Weir Phillips Heritage

Re: Amended Concept Proposal for Cockle Bay Wharf (SSD 7684), 17-27 Wheat Road, Sydney – Heritage Response

This letter responds to The Council of the City of Sydney's concerns relating to the heritage impact of the amended concept proposal for Cockle Bay Wharf (SSD 7684). The heritage objection is outlined below:

MARKET STREET ACCESS ROUTE

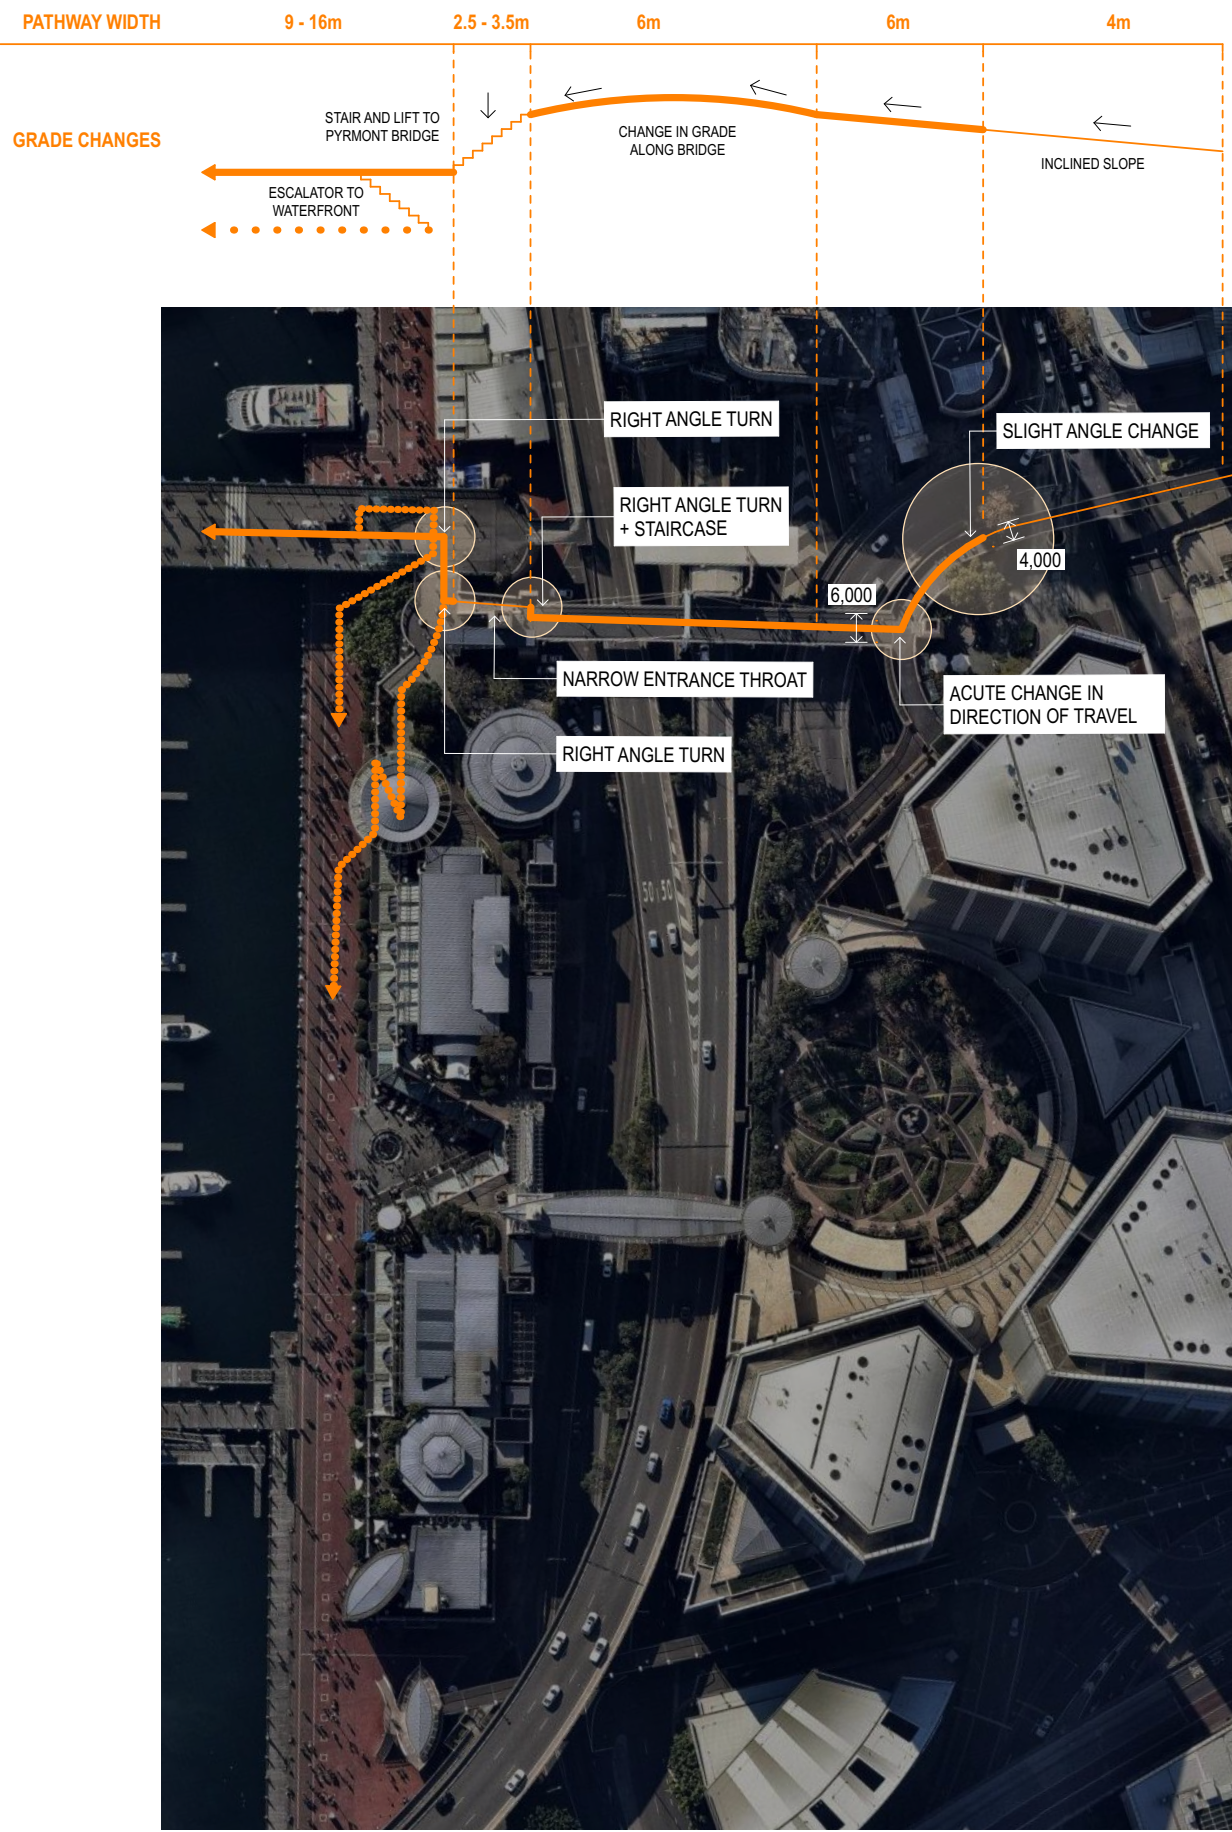
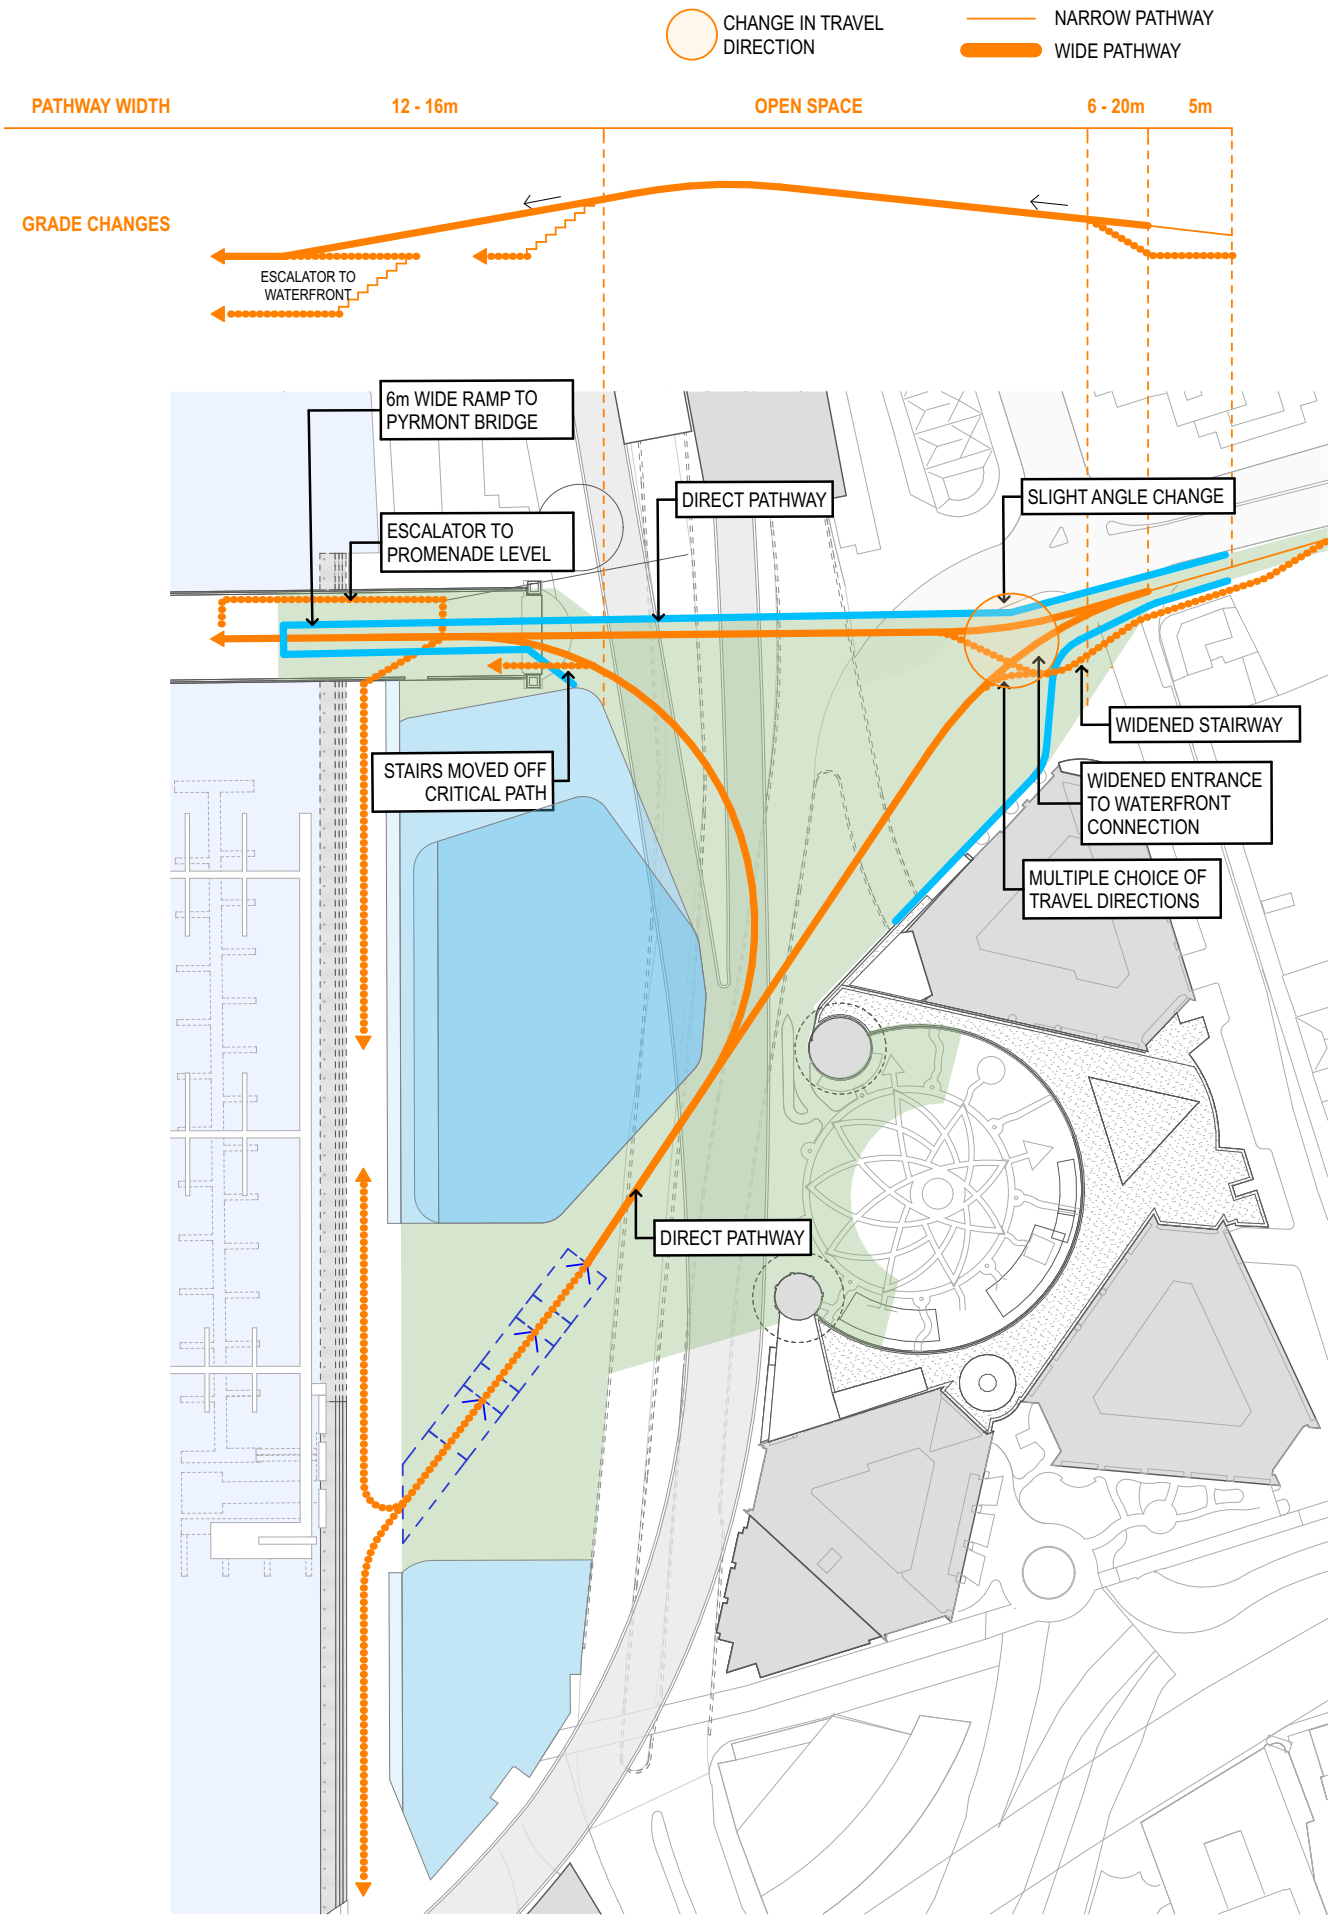
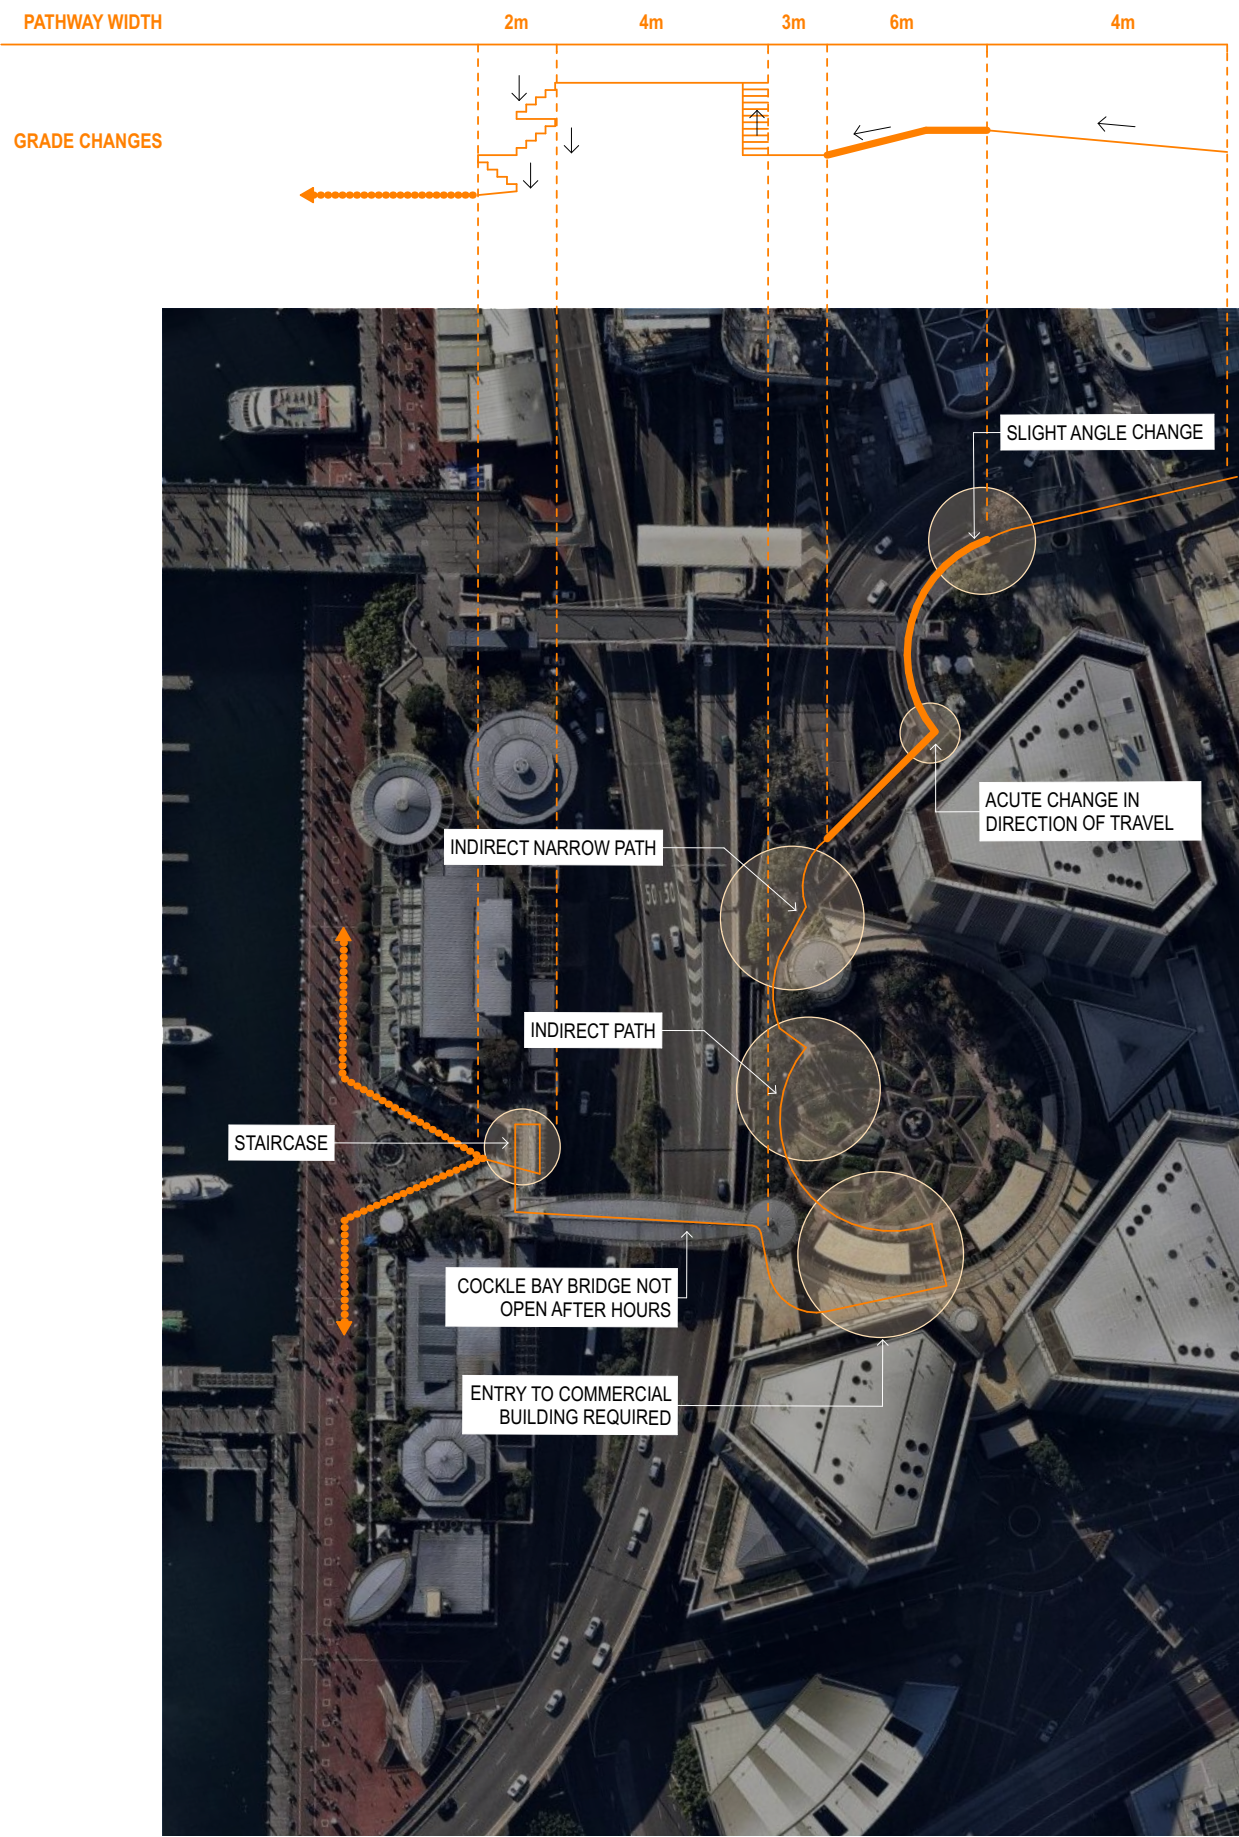
The proposed connection from the amended terraced public landscape to Pyrmont Bridge had been amended. It now connects to the east bridge abutment added in the 1990s and is potentially acceptable. However, the submission mainly uses photo montages and sketch plans to describe this work. Some of these images appear to indicate that the new bridge will cut much closer to the historic Corn Exchange building than existing bridges. This would not be acceptable. In particular, the detailing of the north edge/road portal of the proposed land bridge requires careful detailing as it will be seen as a road portal along the axis of Market Street from the east. The alignment, design and detail of the Market Street land bridge link to Pyrmont Bridge must be resolved to enhance the setting of the Corn Exchange and ensure a high quality and resolved design of the north edge of the new bridge. The detailed design of the connection to of Pyrmont Bridge must be resolved with the input of heritage architects and articulated in the heritage impact statement.

The proposed interface with the pedestrian link and the Pyrmont Bridge will utilise the existing modern fabric connections to the bridge, see **Figure 2** below. The connection will utilise the existing pedestrian link on the far eastern point of the bridge and connect to the lower terrace via staircases and escalators. This option provides an axial connection with Market Street as well as a wider and improved egress for event mode and day to day operation.

This option also allows for the removal of the existing side pedestrian access to Pyrmont Bridge, this will have a positive heritage impact as the profile of the southern elevation will be visible in full. The alignment, design and detail of the Market Street land bridge link to Pyrmont Bridge will be resolved to enhance the setting of the Corn Exchange in the detailed design phase. The Design Architect will consult with Council's Heritage Officers during the design development phase.
